Subject: RE: Fw: Sea Point, 20 Sea Drive, Felpham, PO22 7NE FP/100/15/PL

Paul Cann
Senior Engineer (Drainage & Coastal)

Section 106 connection into existing storm manhole (adopted)
Scale 1:20

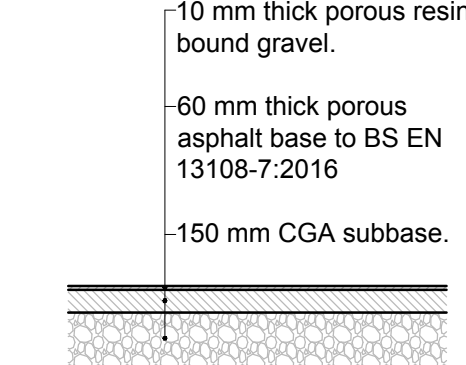
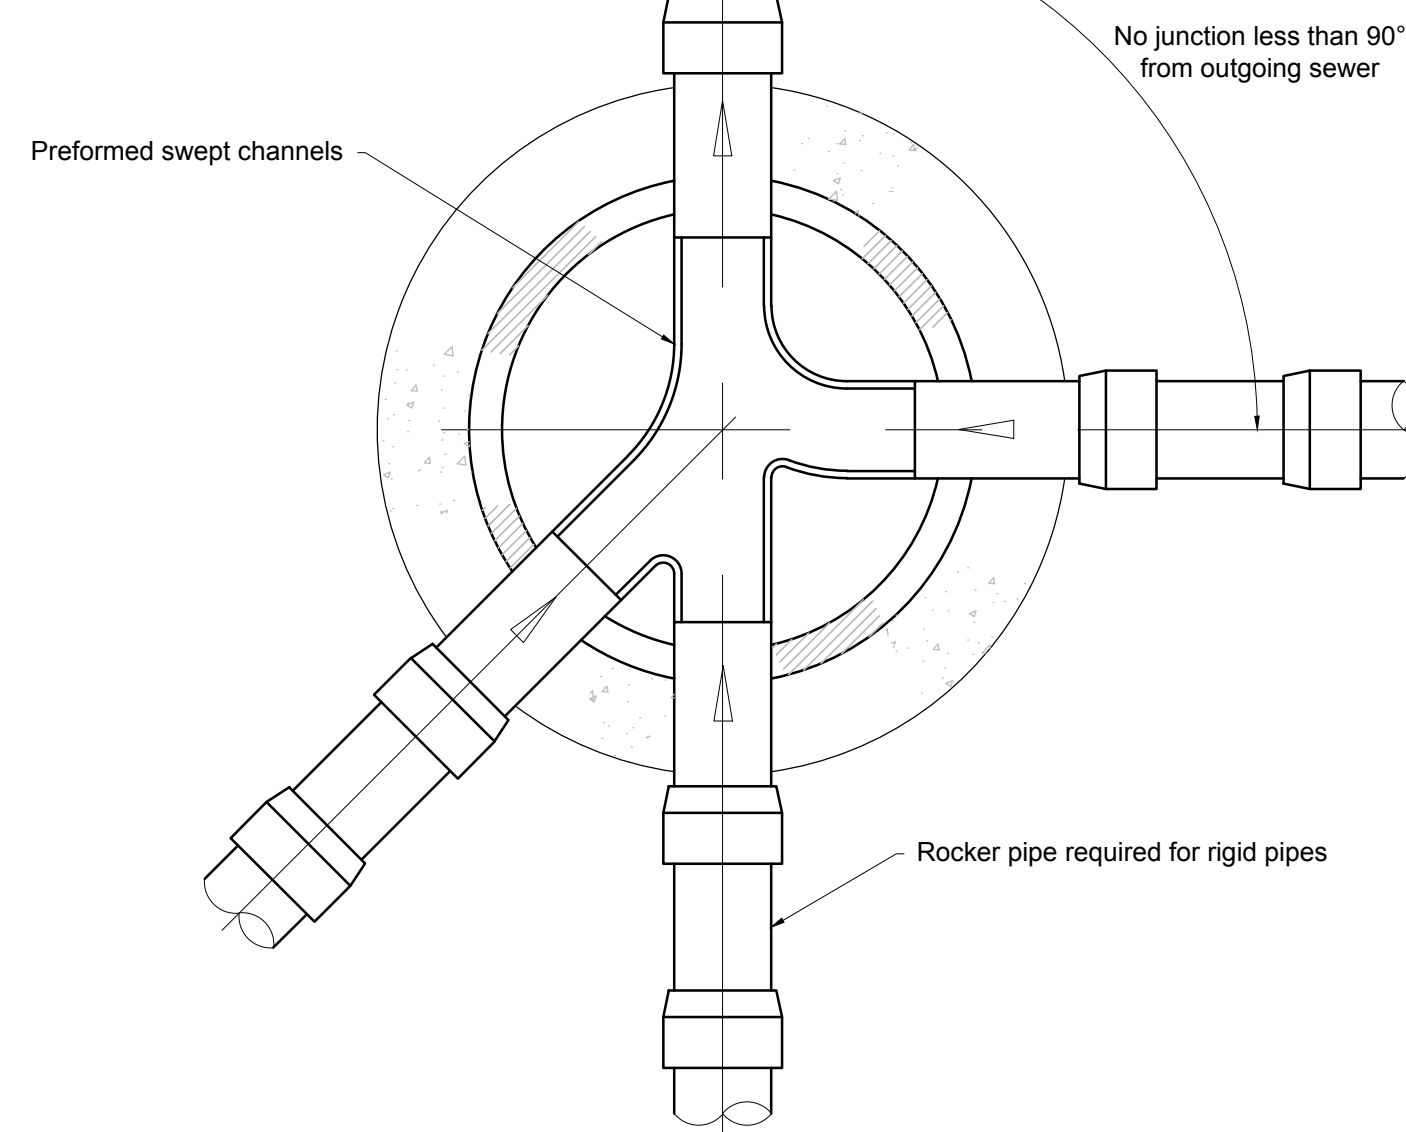
3. Show pipe gradients on layout plan.
4. Provide further details of connection to public surface water sewer ie. external backdrop with connection at soffit to soffit level? Indicate on drawing including connection levels.

5. The calculations show the discharge level to be 45.99 (0.82m AOD). This suggests that the connection is not being made at soffit to soffit level. A connection at the invert level of the 675mm diameter public sewer would not be acceptable.

Porous driveway construction
Scale 1:20

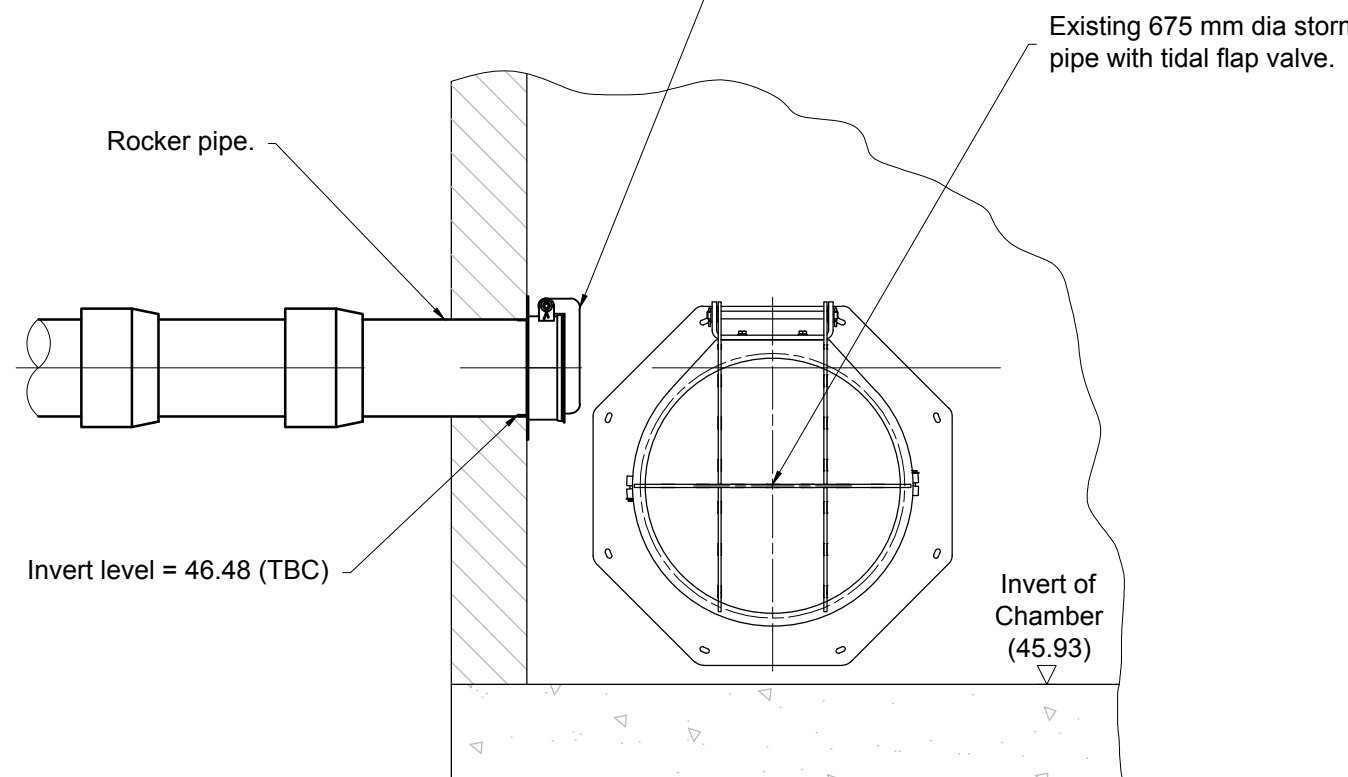
13. Noted
14. The granular sub base for the permeable pavement will require a flat formation in order to ensure that water does not all collect at one end, unless you wish to incorporate stanks. If you do not incorporate stanks, then the sub base thickness will need to increase where necessary. Please adjust details.
